WEST SUSSEX COUNTY COUNCIL CONSULTATION

TO:	Arun District Council - FAO: Simon Davis
FROM:	WSCC - Highways Authority
DATE:	17 June 2021
LOCATION:	Land At Little Meadow And East Of Bilsham Road, Yapton, BN18 0JY
SUBJECT:	Y/71/21/OUT Outline application with access for up to 73 No. new dwellings (but retaining Oak Trees & Little Meadow dwellings), 405 sqm of new light industrial buildings as part of an enlarged employment site & Public Open Space. The existing junction of Grevatts Lane West & Bilsham Road will be closed & Grevatts Lane West diverted to a new access point to the South. This application may affect the setting of Grade II Listed Buildings & is a Departure from the Development Plan.
RECOMMENDATION:	More Information

Junction Arrangements

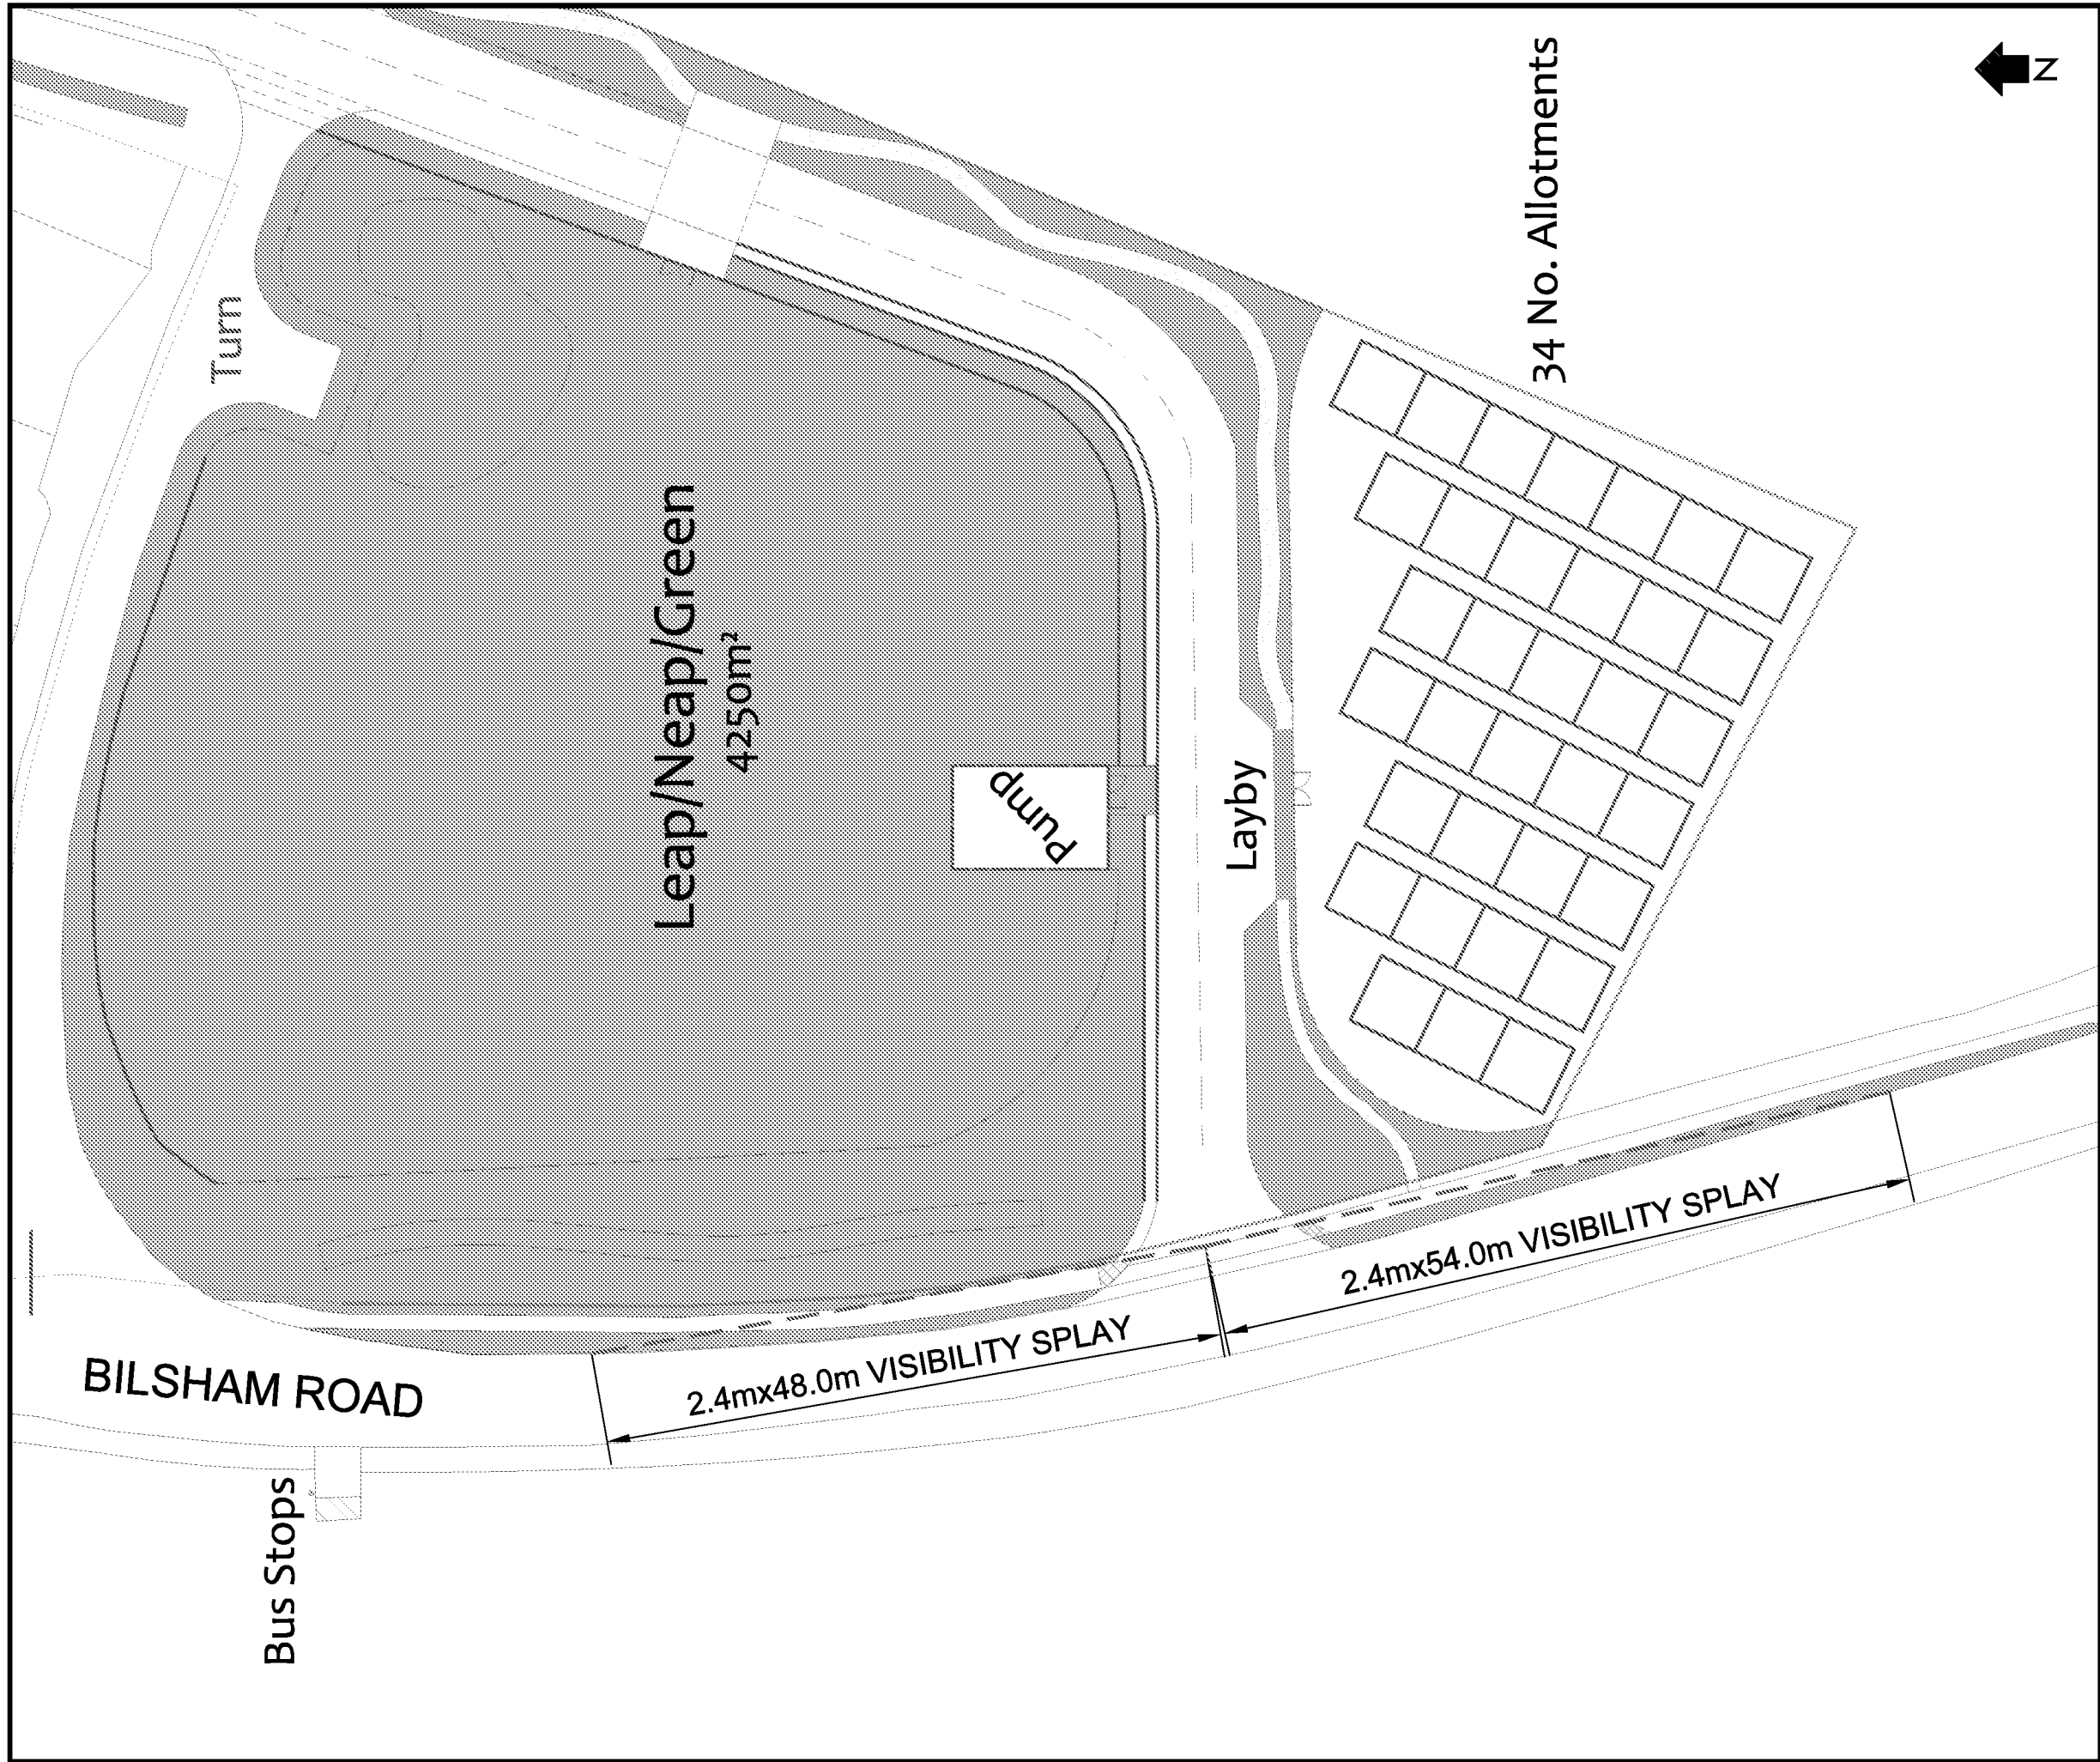
A new bellmouth junction to Bilsham Road is proposed to the south of GLW/Bilsham Road junction. Swept path tracking shows that a refuse collection vehicle and car can pass within the access. There also appears to be a proposed tactile dropped kerb paving point either side of the new junction. The applicant should also explore localised widening of the footway on Bilsham Road.

The existing GLW junction affords substandard visibility yet is shown as retained for access only to the existing 4 x dwellings only. Considering the substandard visibility, the applicant should consider closing off this access with the new junction and access road

providing a route to the existing dwellings. The turning area shown opposite Bilsham Cottage should also be demonstrated as workable.

3.3.1 – Visibility at Proposed Junction – the auditor recommends that existing hedge and bank are accounted for in visibility splay assessments. As the LHA require correct splays to be demonstrated it should be shown that these are not impacted by bank or third-party land. The bank does not appear publicly maintained so will only be able to be regraded where it is within the applicant red edge.

3.4.1 – Lack of Pedestrian Facilities – the auditor recommends a pedestrian crossing point with drop kerbs and tactile paving are provided across the new junction.

The Designers Response states that a widened footway and crossing is shown on drawing NJC-001. The extent of footway widening, and pedestrian crossing should be made clearer when the visibility splays are redrawn.

- Demonstrate required visibility splays to 85th percentile speeds, ensuring these do not pass through third party land (ensure bank and trees do not impact splays). Also provide detailed location of speed counter.
- Demonstrate clearer access and site plan, show proposed localised footway widening, footway tie in to site and existing and dropped kerb tactile paving

pedestrian crossing point of the new junction and of Bilsham Road to the west side bus stop.

- Explore option of closing off/stopping up GLW junction and demonstrate turning area for the existing dwellings is workable from the new access road direction.
